SUBJECT: Engineering Review Comment  
Mountain View Electric Association Inc. (MVEA)

**Project Name: Kettle Creek Estates Filing 2 – Replat of Lot 1 Kettle Creek Estates**  
**Project Number: VR246**

Description: A proposed development of 2 residential lots located at Old Ranch Rd. and Otero Ave. in Township 12S, Range 66W, Section 28.

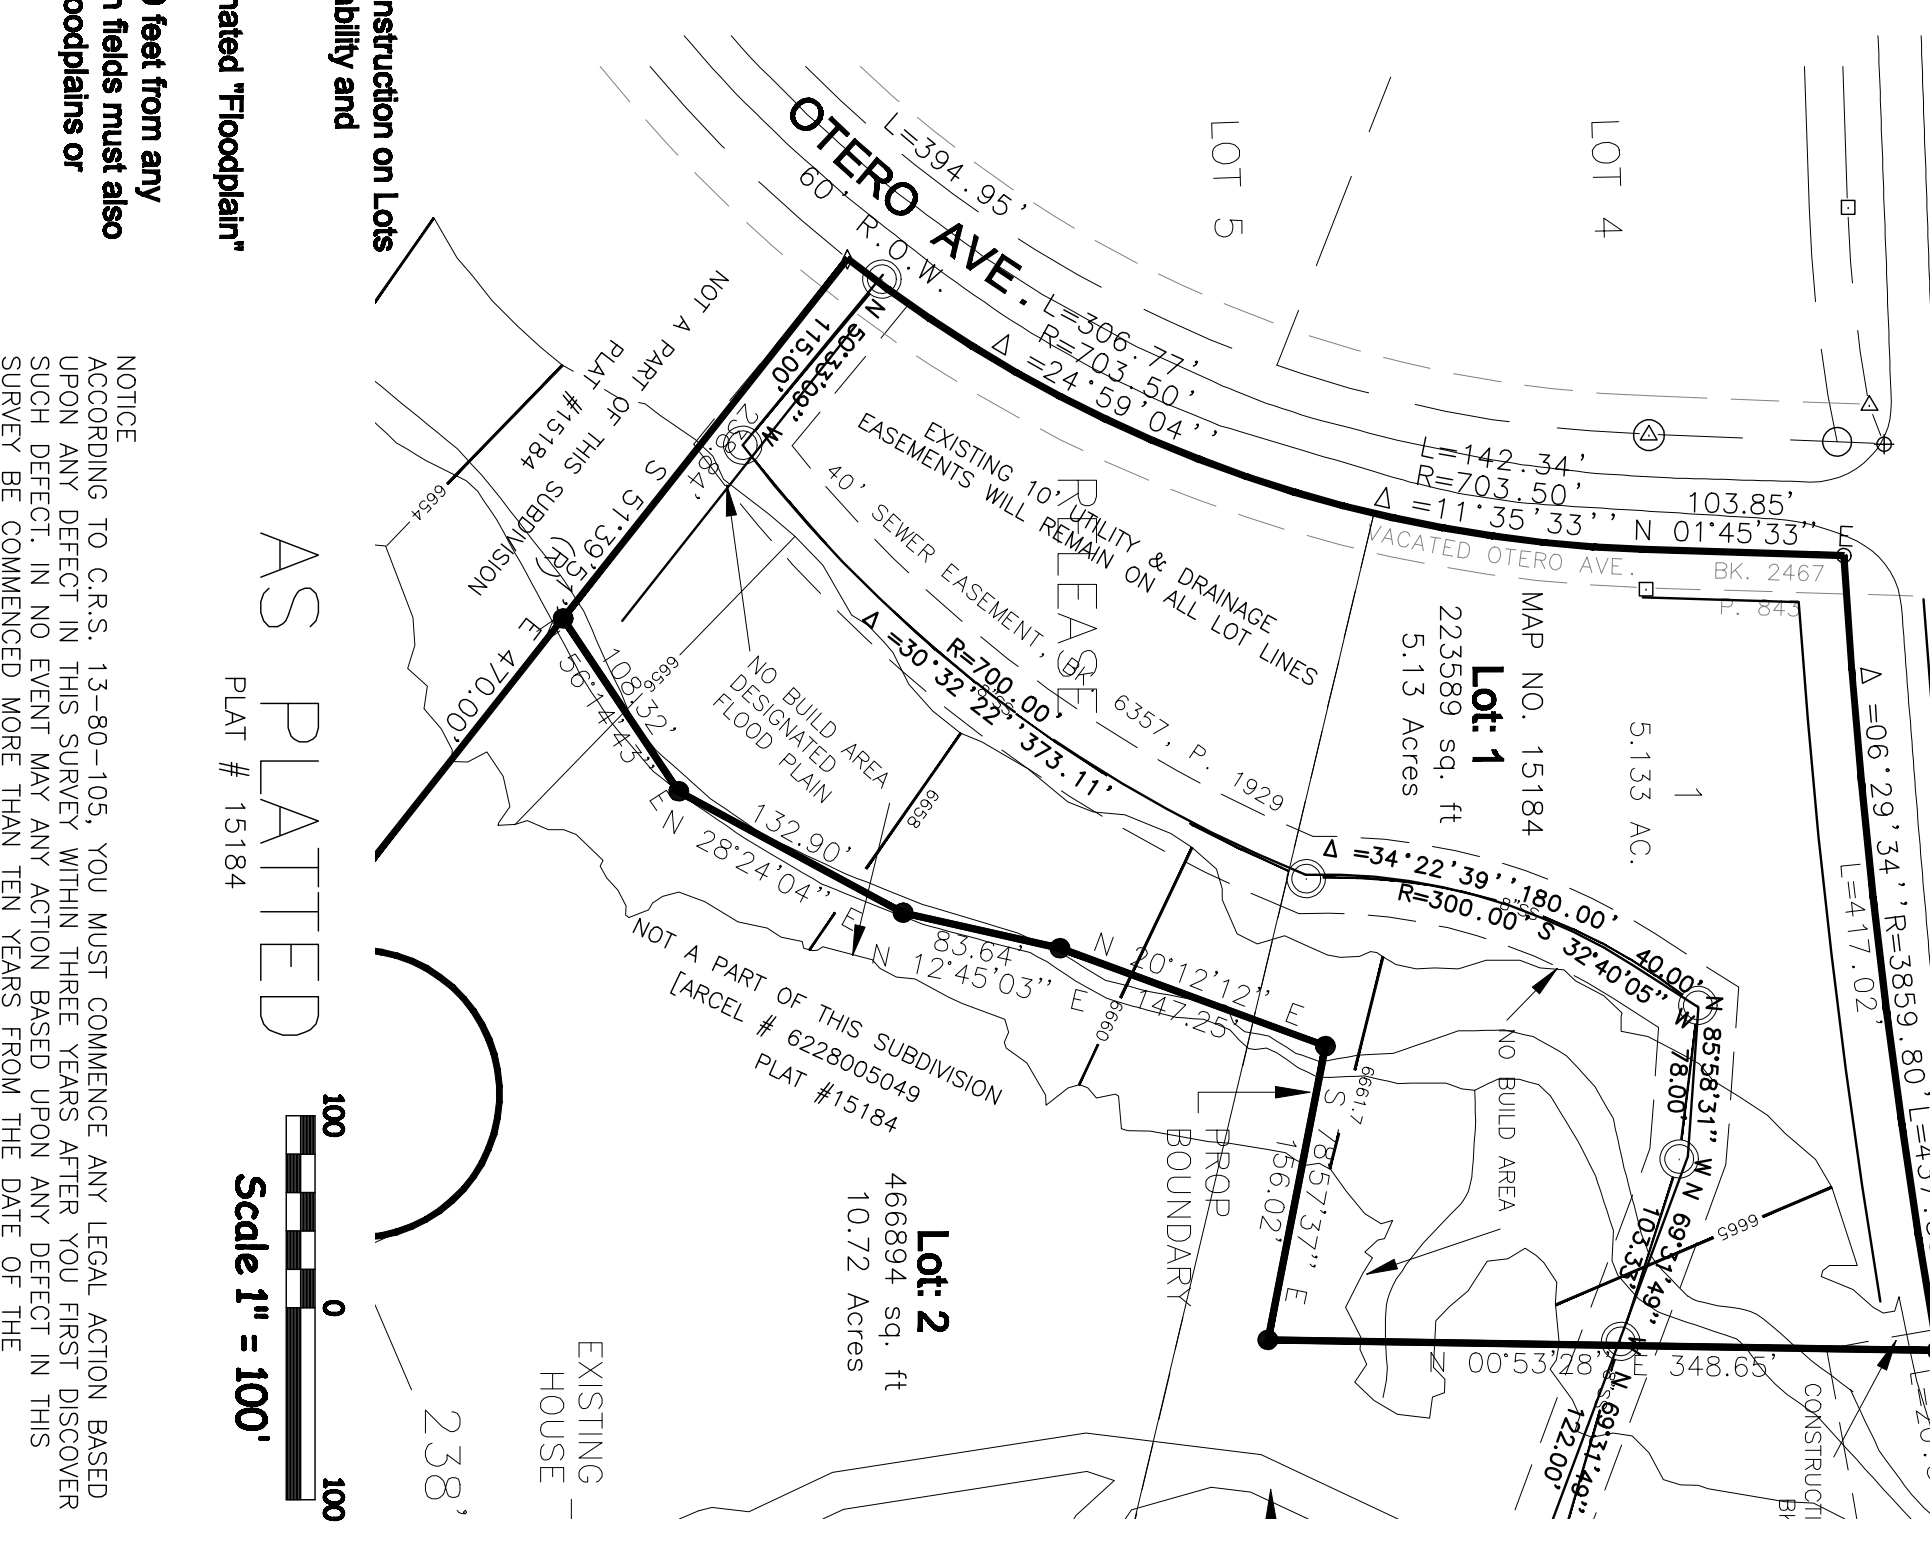
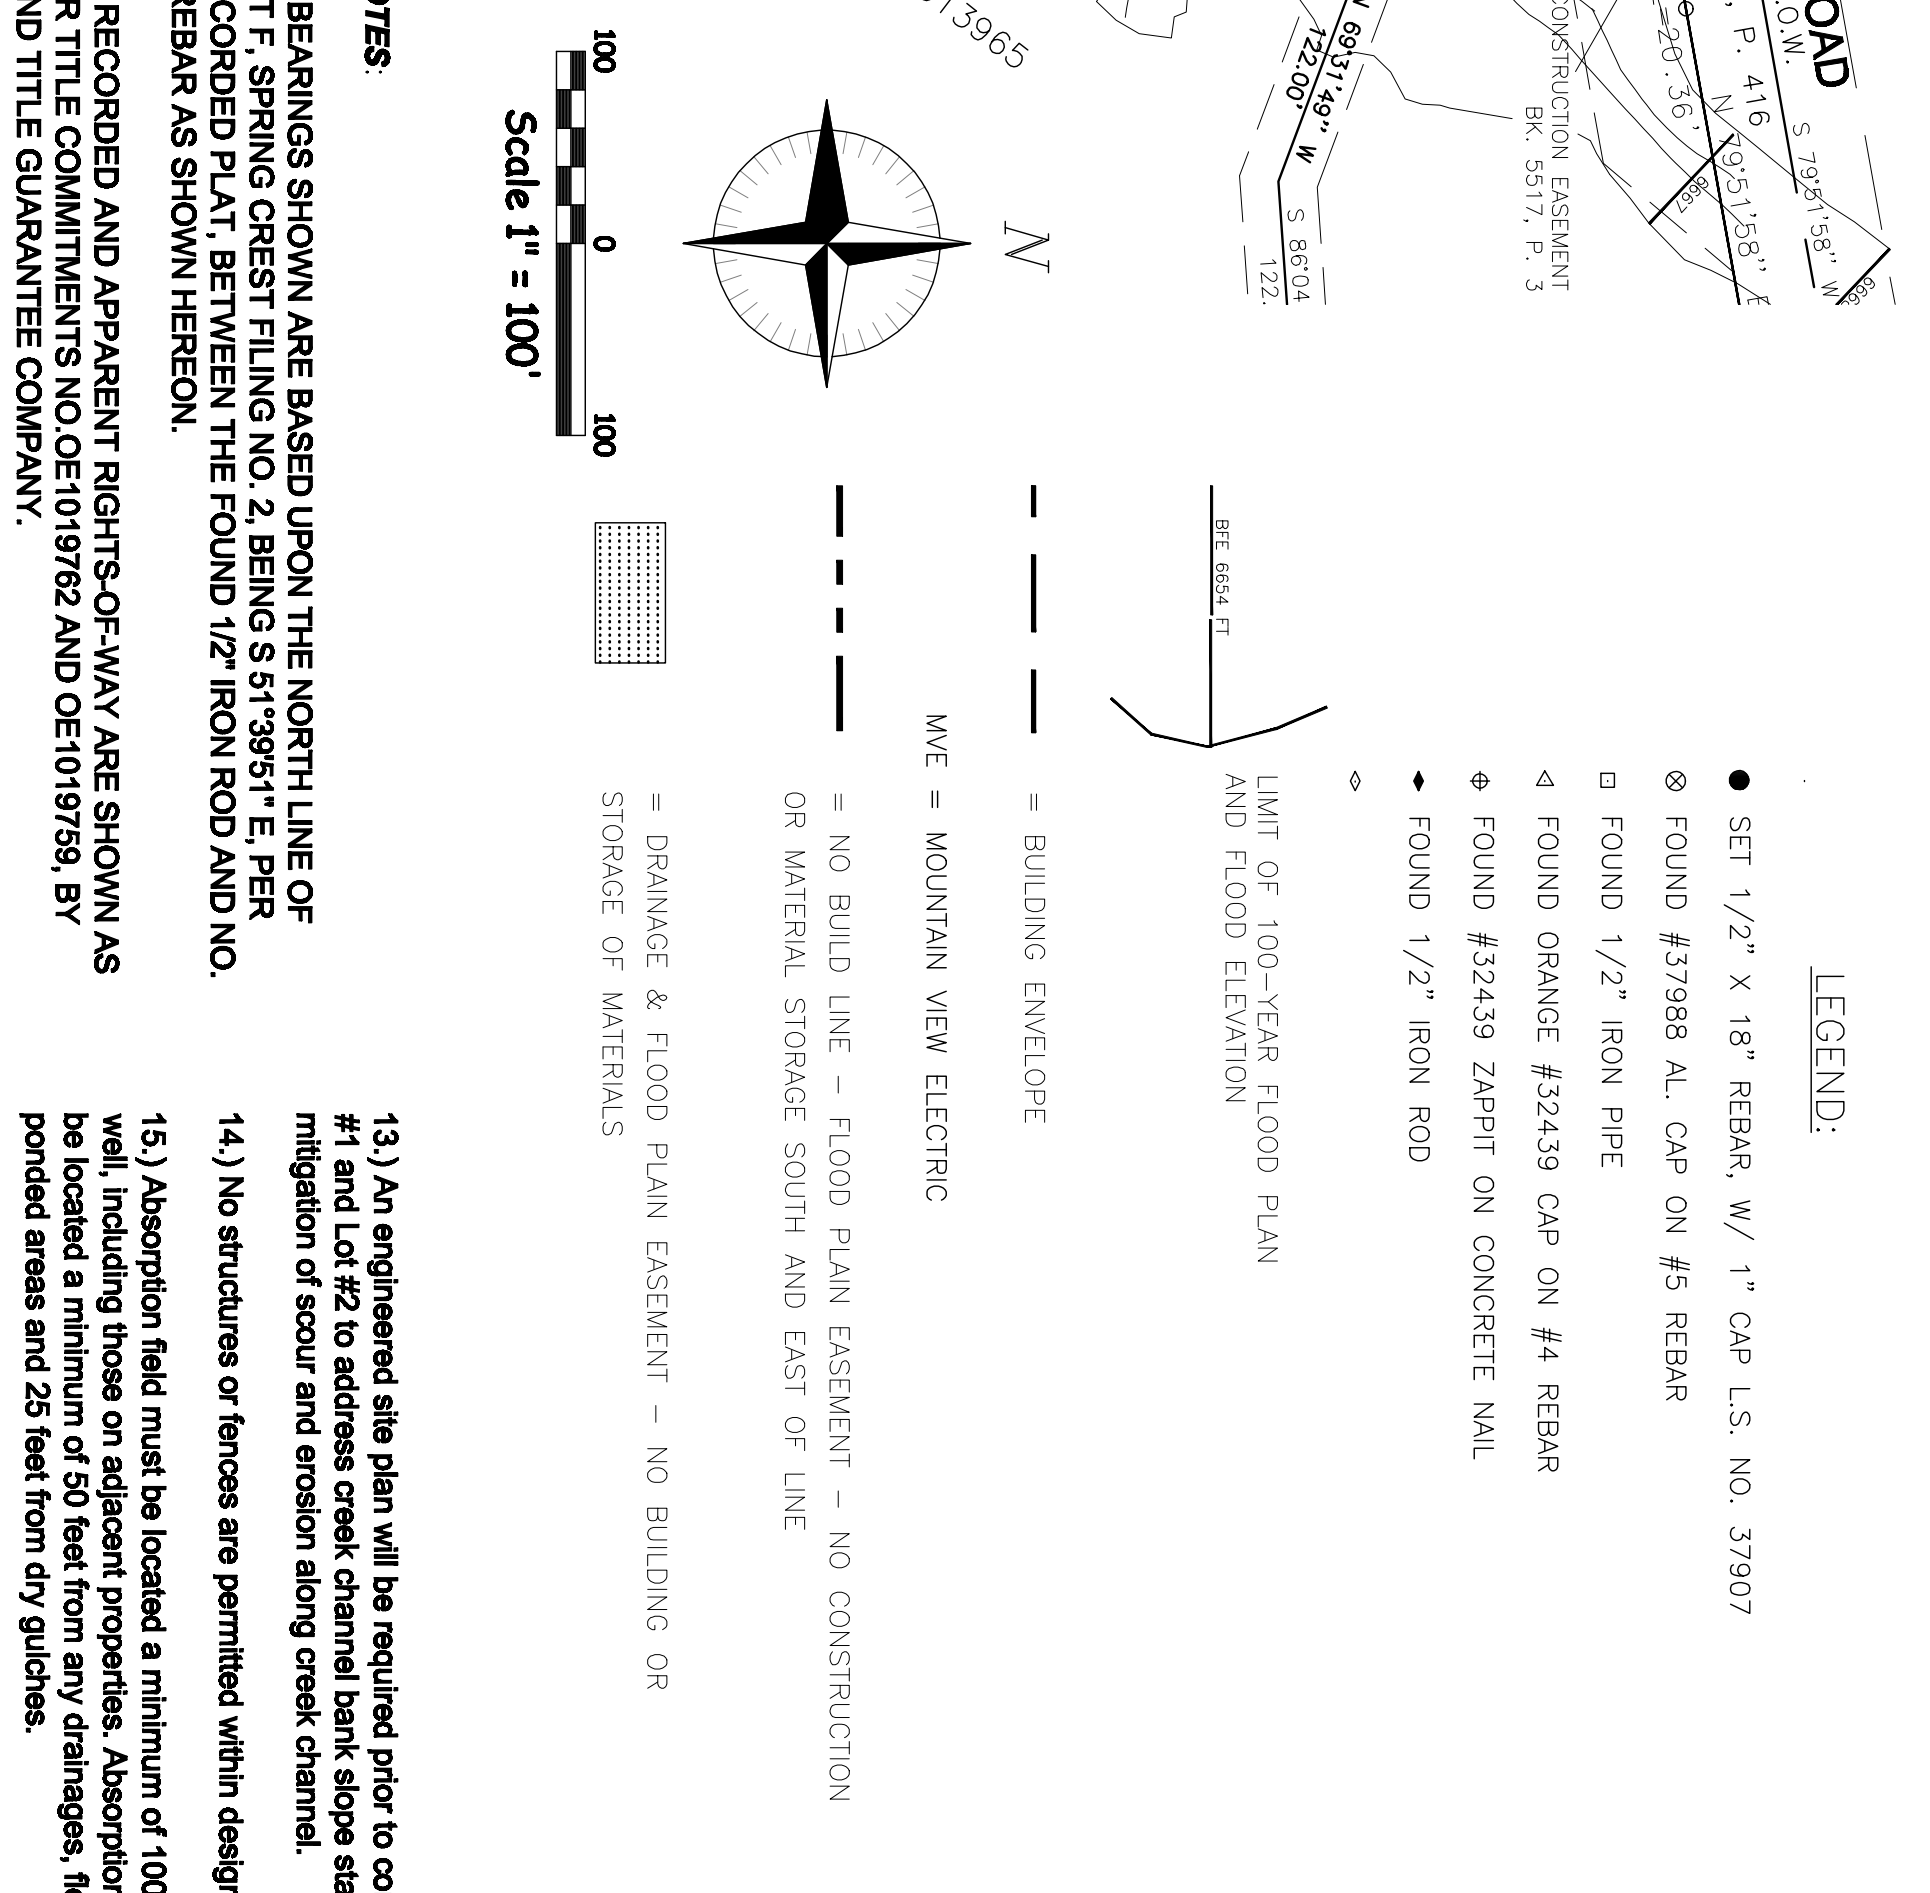
MVEA requests a ten (10) foot front, side, and rear lot utility easement and all tracts, along with a twenty (20) foot exterior utility easement on the plat. MVEA also requests the platting of MVEA's existing facilities with easements on the plat. Additional easements may be required.
